Our ref: 25_31414_P
Your ref: H23-0313-25
FAO: Mark Niland

Reference Number: H23-0313-25

Proposal: Provision of new poultry unit & associated works

Location: Land At Peartree Hill Road Whaplode Drove

ACCESS PLAN

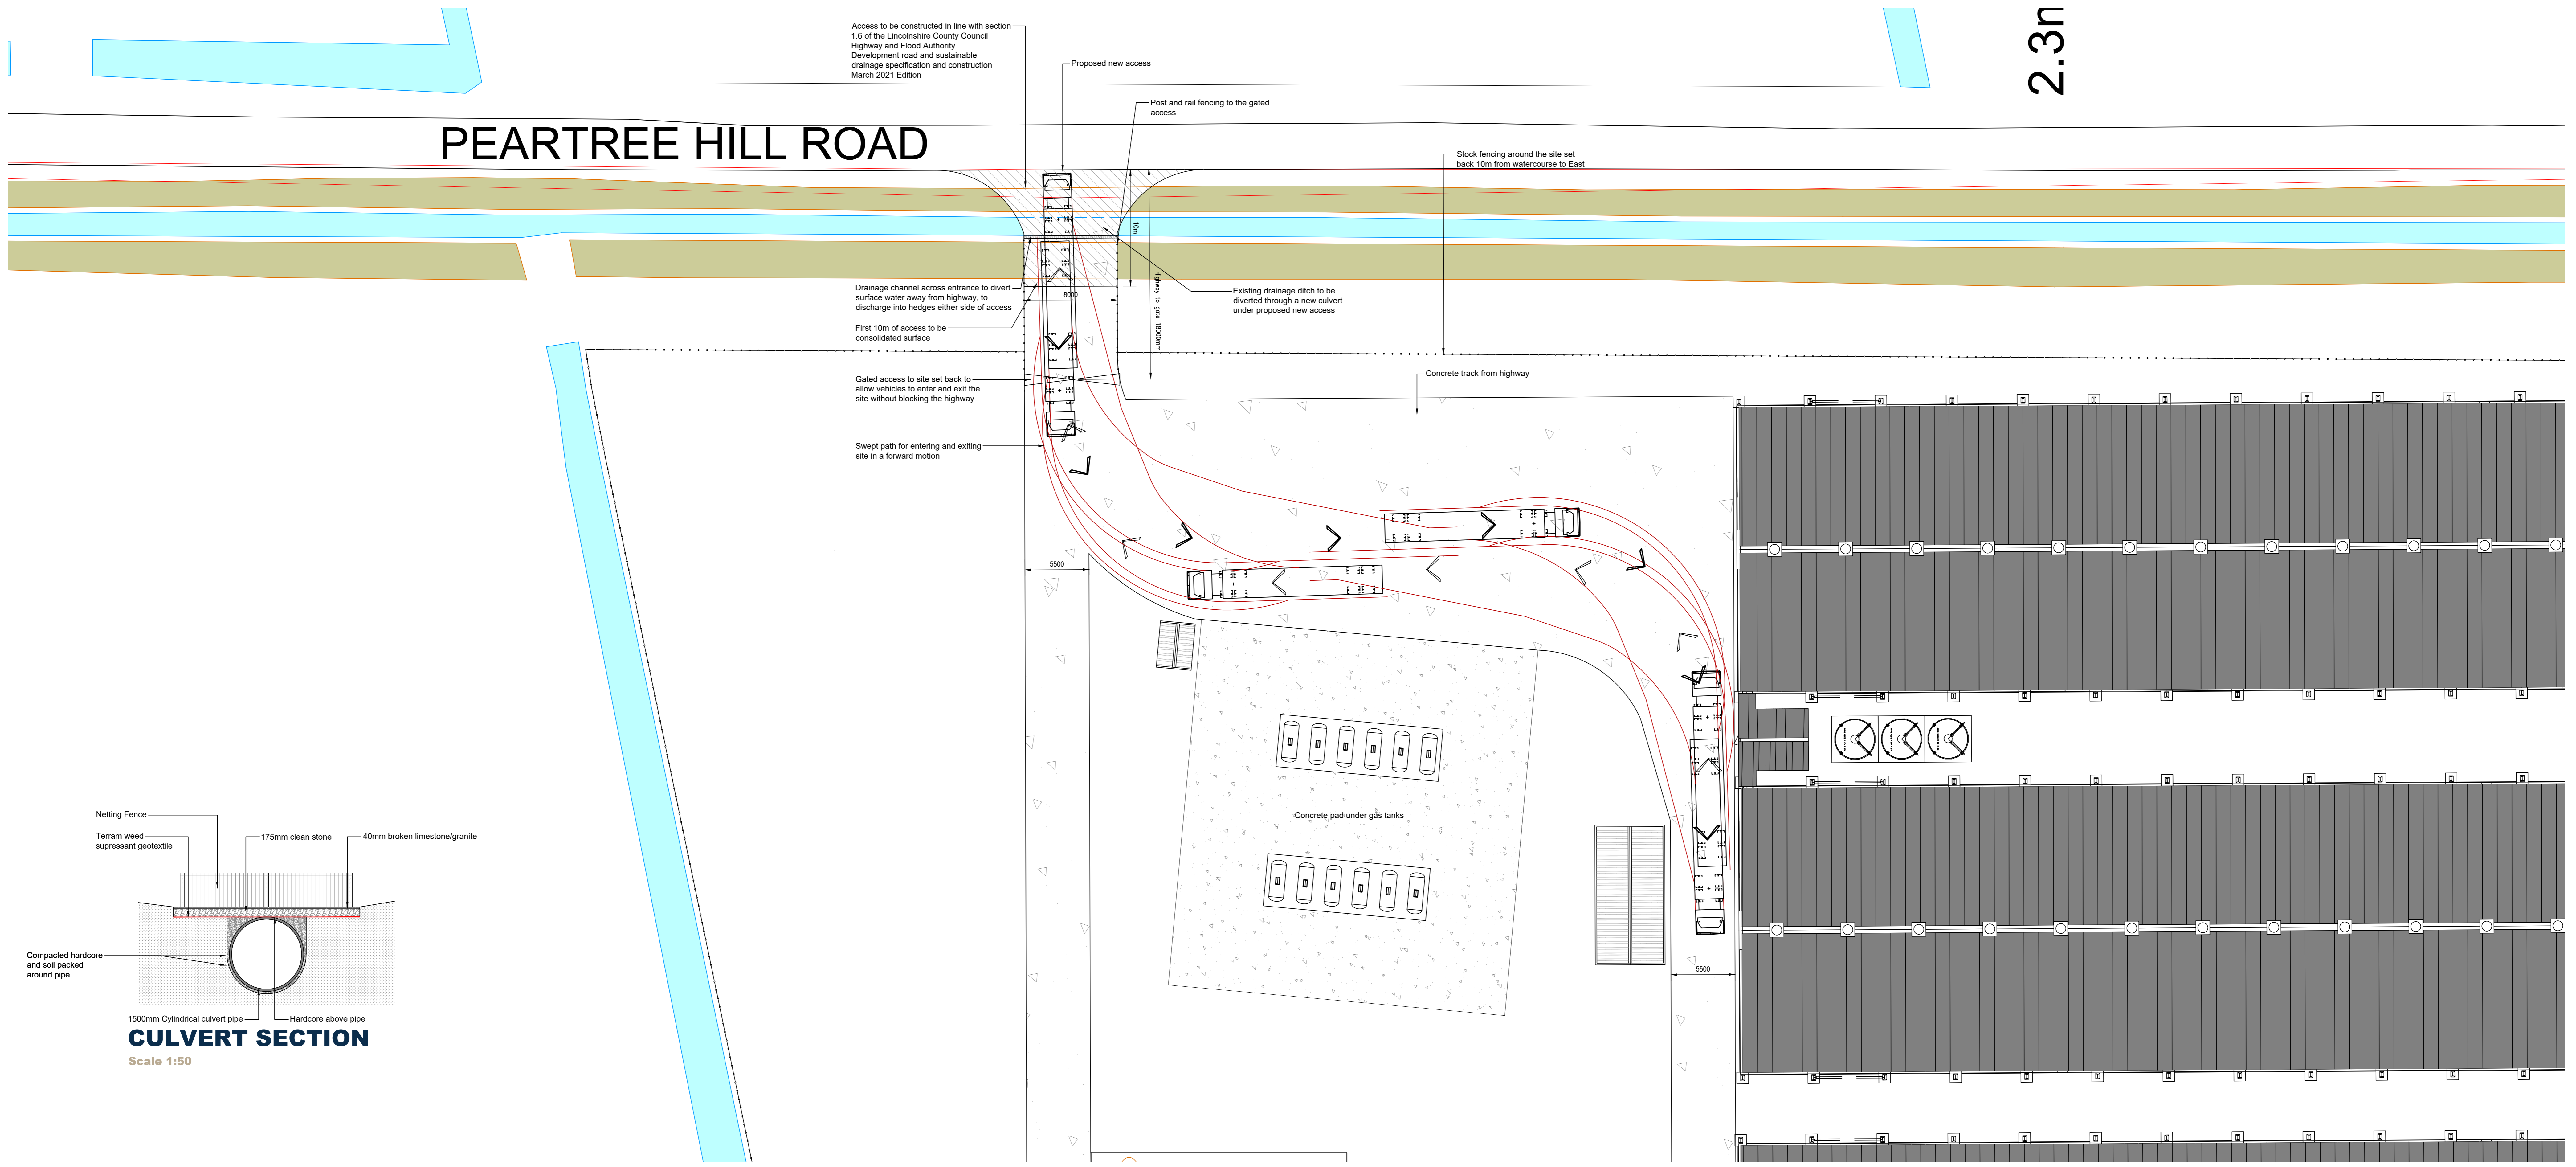
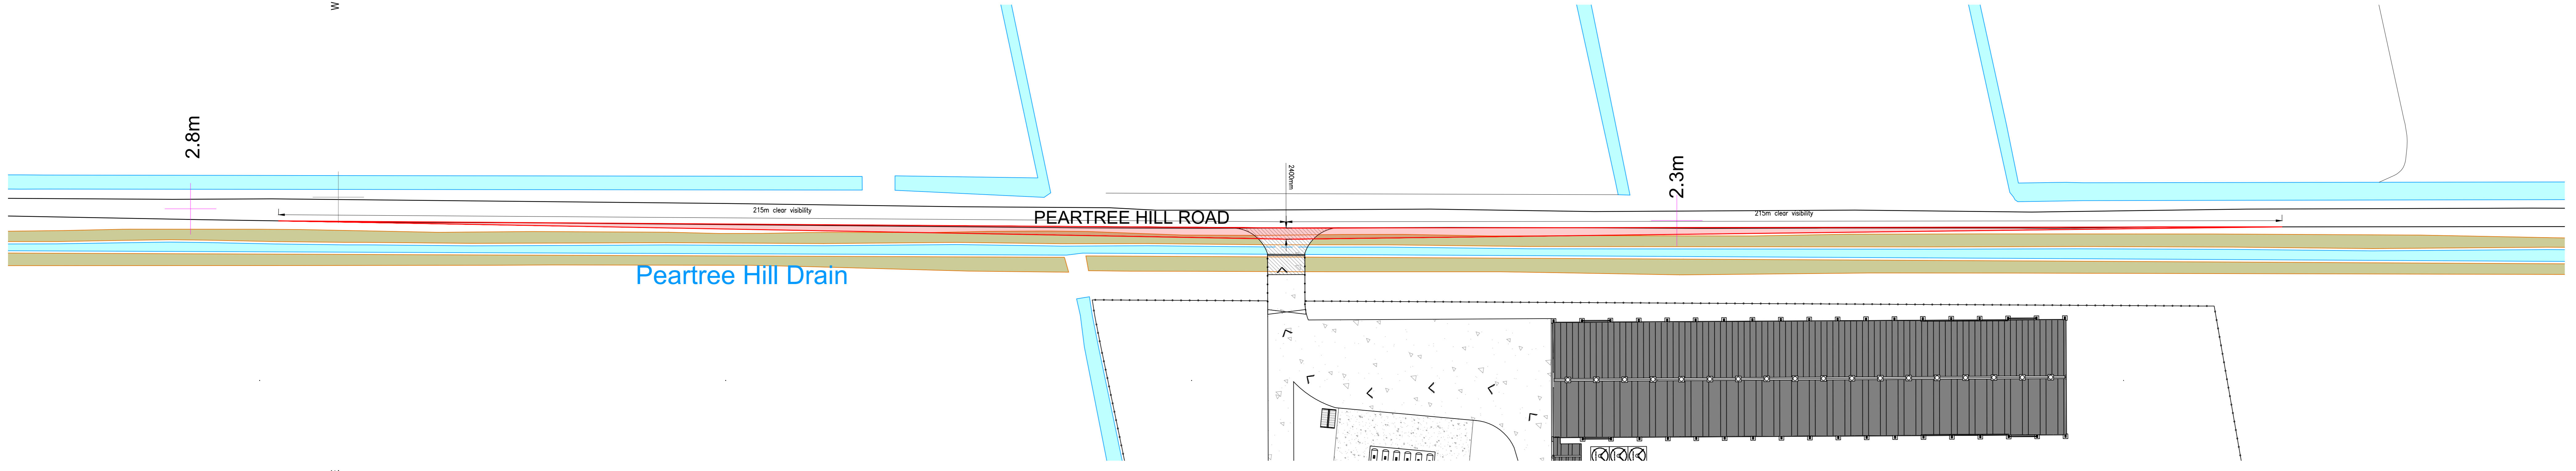
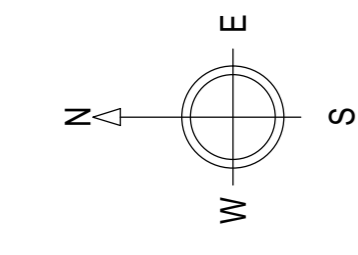
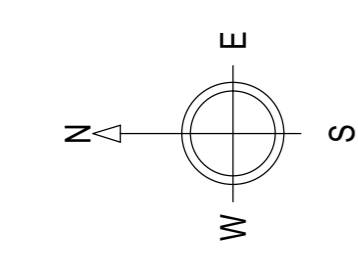
As previously mentioned, the applicant intends to carry out works to alter the Board **owned** arterial watercourse known as C10 Peartree Hill Drain (DRN194P1002), located to the east of the site by installing a new access culvert, as shown in drawing *Proposed Access Plan and Visibility Splay 'JW/2384/0325-200_04 Rev B'* (Acorus, 15.10.2025).

The Board have concerns with the current design of the culvert, and **wish to object** to this aspect of the proposal until the below is addressed:

- We believe that the proposed 1500mm diameter culvert will be too large for this section of watercourse. We recommend that a 1050mm diameter culvert is installed. The culvert should have an invert level of -0.43m O.D.N to allow for future improvements.
- There is minimal cover over the culvert, reducing the pipe size would increase the level of cover. However, the proposed surround and infill material around the culvert is not acceptable to the Board. The Board are able to provide a standard detail drawing as an indicative design and details on the information required for a culvert application, if the applicant/agent would like to approach us to discuss this further.

We also note that the drawing *Proposed Access Plan and Visibility Splay 'JW/2384/0325-200_04 Rev B'* (Acorus, 15.10.2025) states "*Drainage channel across entrance to divert surface water away from highway, to discharge into hedges either side of access*". The Board have previously advised that no planting should be located within 9 metres of the Board arterial watercourse, this includes over the culvert. We request that the hedging is removed from the drawing and a suitable drainage strategy for the road is provided. This aspect of the proposal is not acceptable under the Board's [policies](#), therefore the Board currently **objects**.

We require dropped kerbs to be installed either side of the road within the 9 metre Byelaw Zone to allow access for the Board's machinery to the maintenance strip either side of the road. Please note that the Board will not be held responsible for any damage to the road caused by the Board's tracked machinery when crossing over the road.
